VIP Peak East – Application Reference - 2019/101

Response to HE and BMBC comments on CTMP and Access Drawings

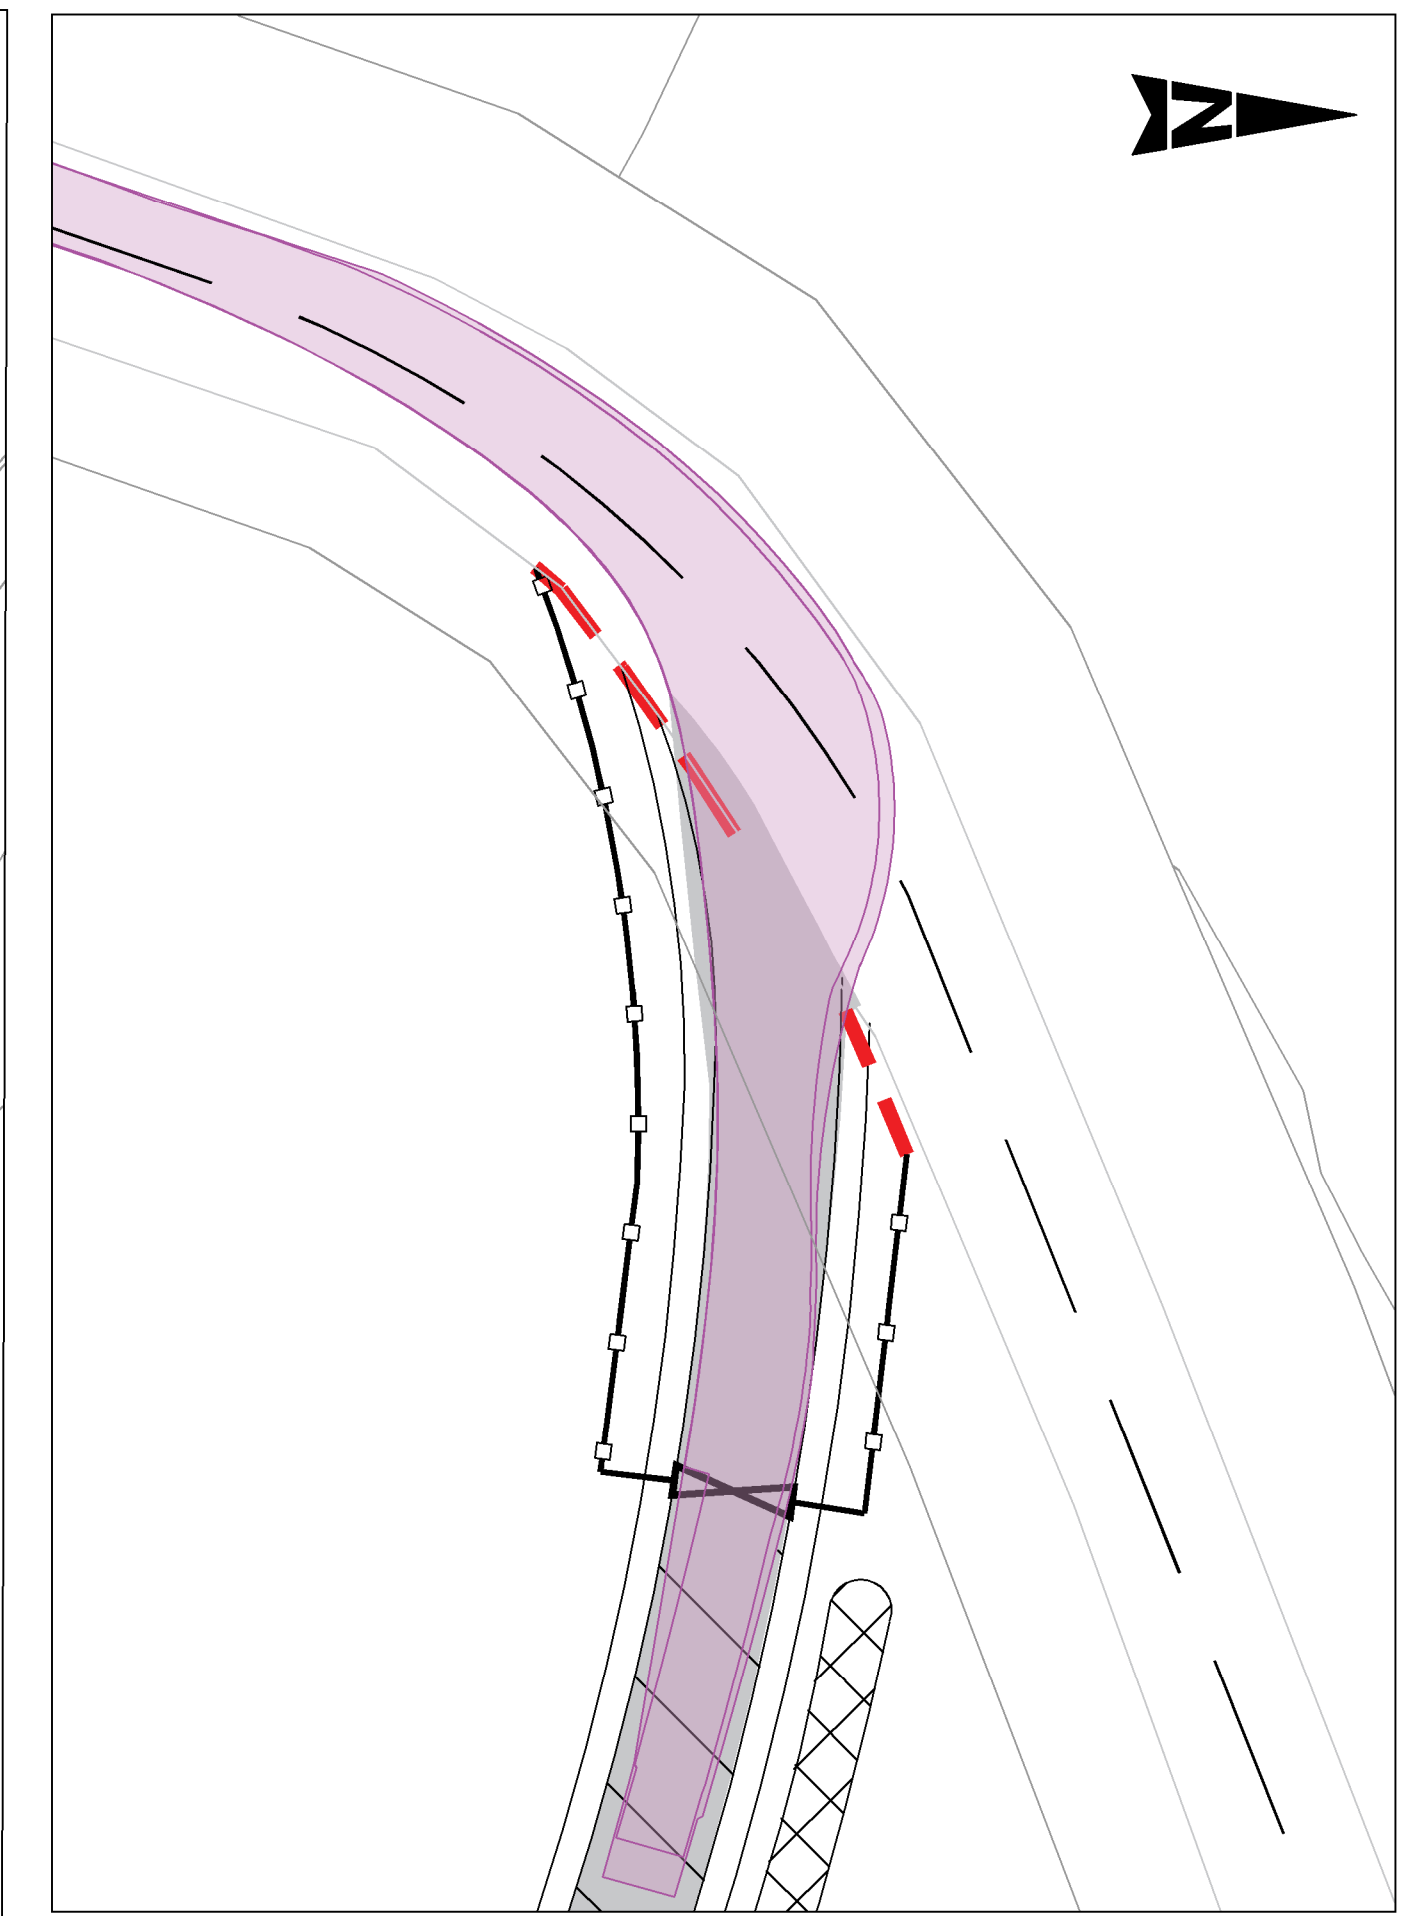
The current swept path analysis of the proposed temporary car park arrangements show a bus reversing within the car park (close to the main entry/exit point). This would be unacceptable for reasons of accessibility, manoeuvrability and safety. Alternative options should be presented whereby a bus does not have to reverse within the car park and can safely access the stop to pick up and set down passengers.

In addressing BMBC's comments, the temporary car park layout has been redesigned to allow a full size bus to make a 180° turn without having to make reversing manoeuvres. The revised layout provides 18 standard parking bays, two disabled bays and a horsebox parking bay as shown in drawing no. PDD-33492-LAY-082.
